Ribble Valley Borough Council

App no: 25.0688

Address: Former Genus Site (Units 1-21 Mitton Road Business Park) Mitton Road Whalley BB7 9JY

Proposal: Proposed reinstatement of previously approved phase 1 entrance, including a timber fence between phase 1 and phases 2/3

Client <b>A I Land Ltd</b>		
Project <b>Proposed Alterations to Phase I Entrance at Mitton Road Business Park Whalley</b>		
Drawing Title <b>Existing and Proposed Site Plans</b>		
Scale <b>1:500 @ A2</b>	Date <b>Aug 2025</b>	Drawn <b>LFR</b>
<b>READ DESIGN LTD</b>		
<b>102 - 09 B</b>

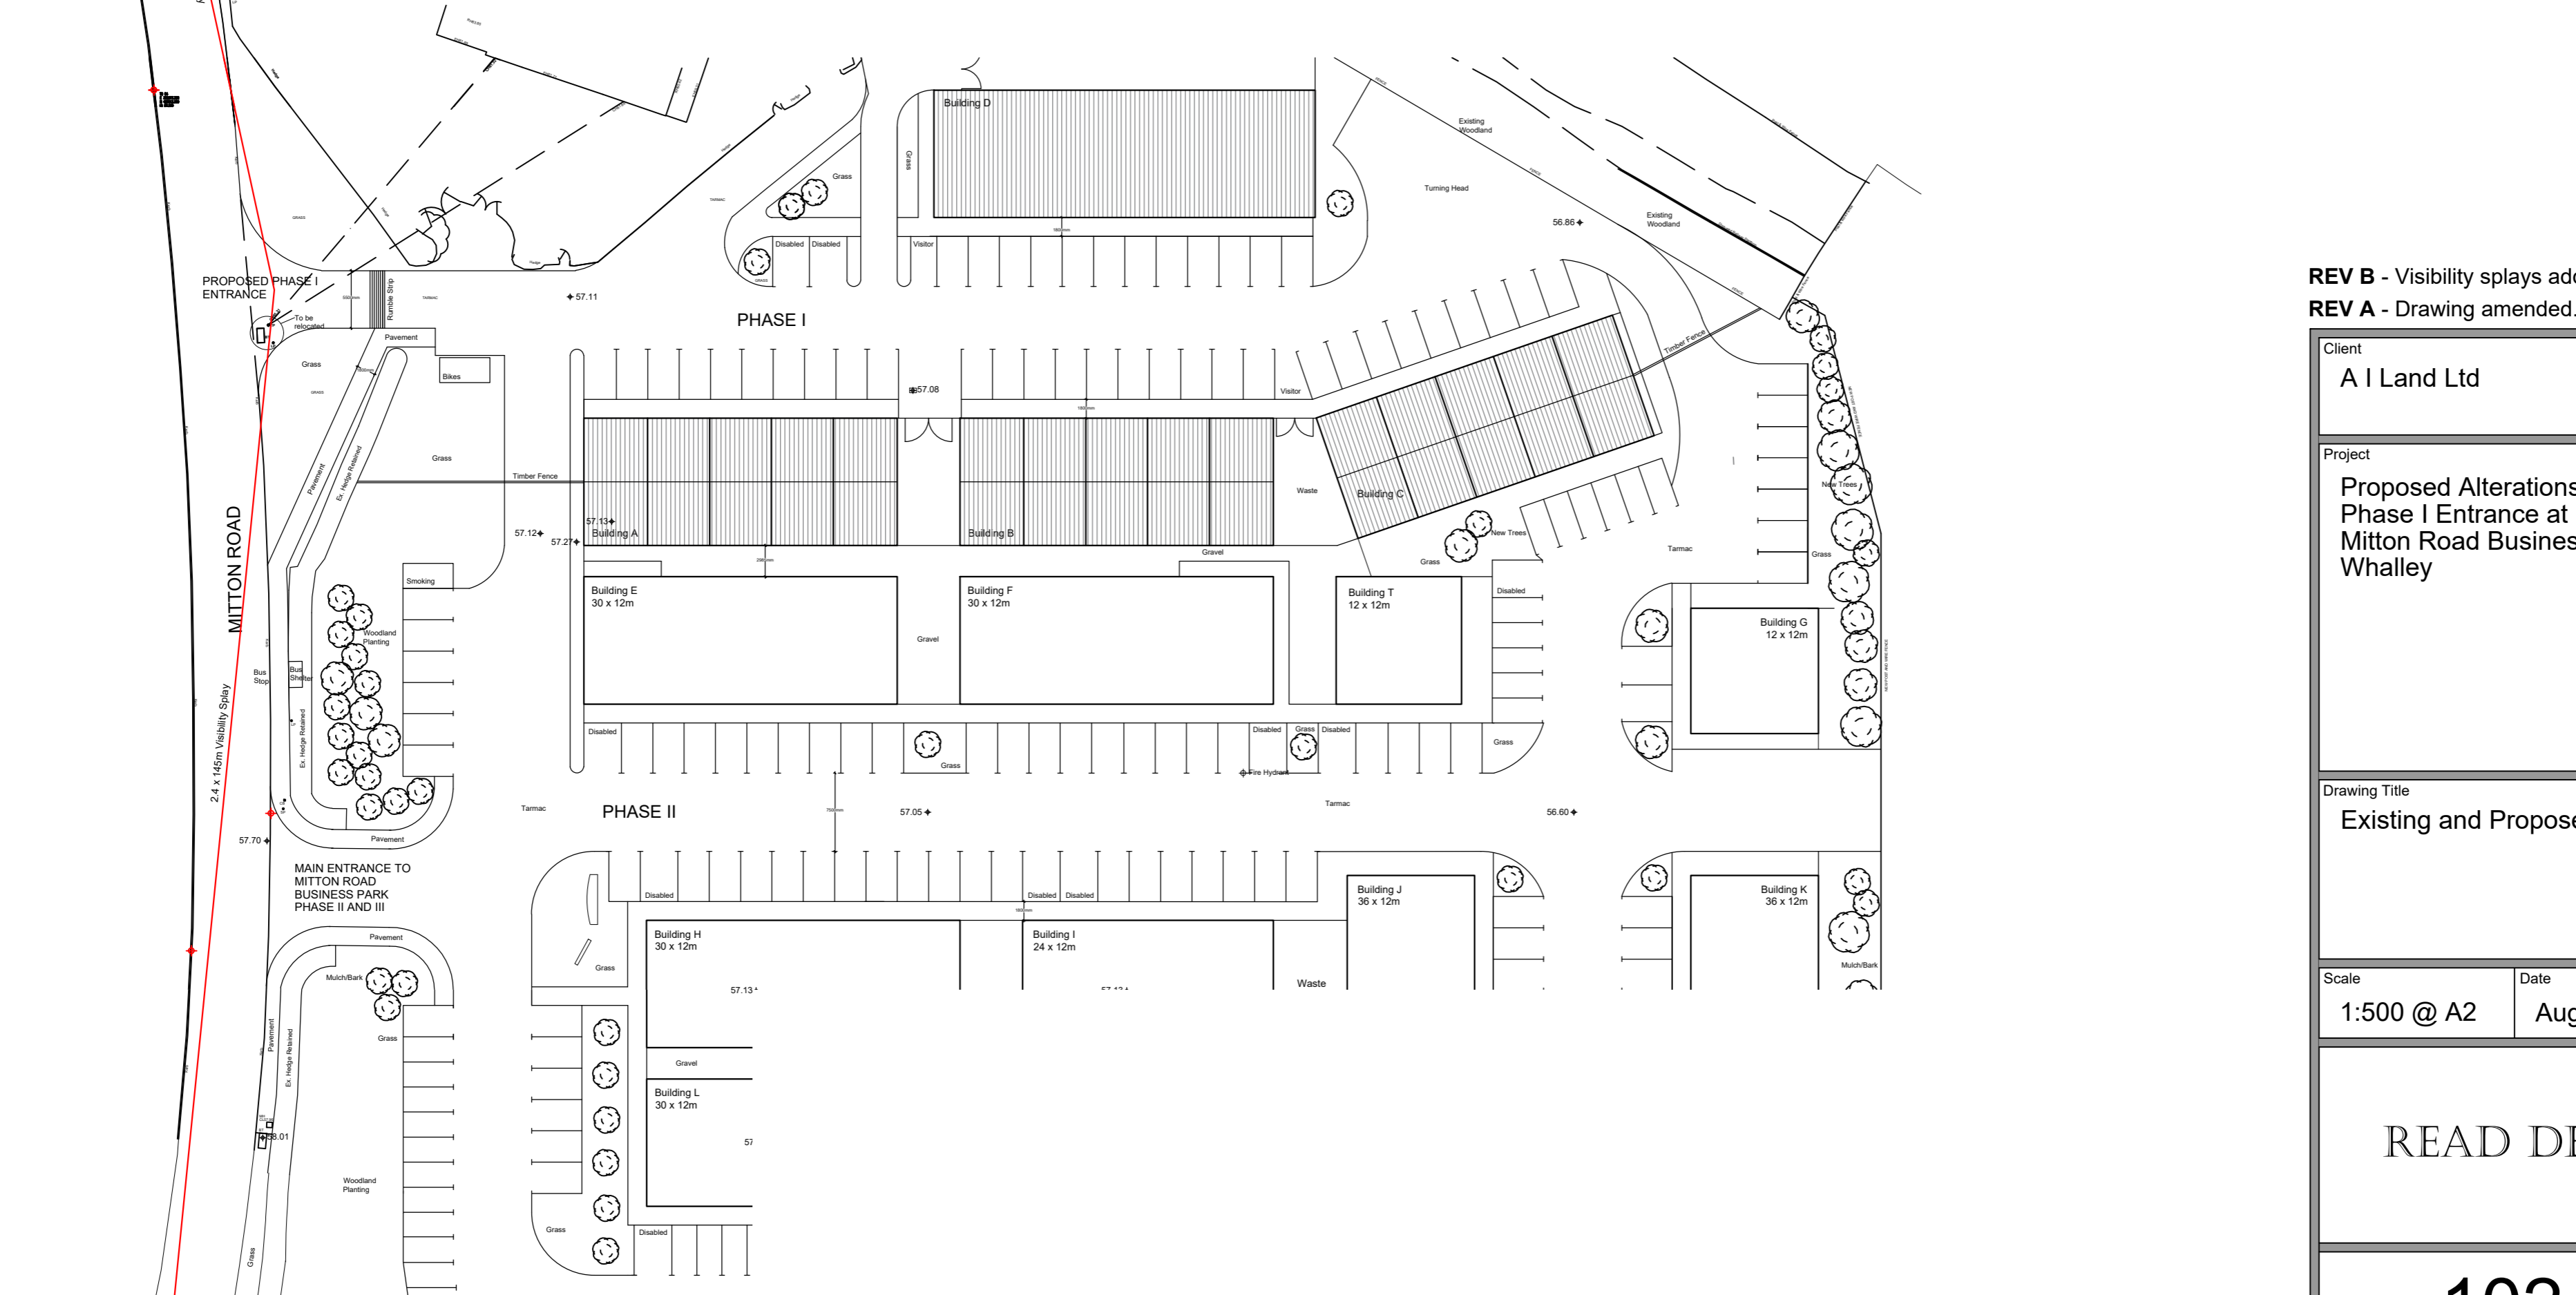
The visibility at the site access is considered acceptable. Splays of 2.4m by 90m to both sides are required and can be achieved over the highway or applicants land.

The access is proposed to be widened to 5.5m however this is not considered acceptable and will require widening to 7.5m to accommodate the articulated wagons which are using the site access. This was observed during my site visit.

The proposed internal separation of Phases 1 and 2 will prevent access to the communal parking areas for the Phase 1 units. It is recommended that pedestrian access is maintained between Phases 1 and 2 for overspill car parking unless additional information is submitted to demonstrate that the proposal will not impact upon parking.

Lancashire County Council acting as the Highway Authority would request further information regarding the reason for the proposal and that the access is proposed at 7.5m carriageway to accommodate the large commercial vehicles.
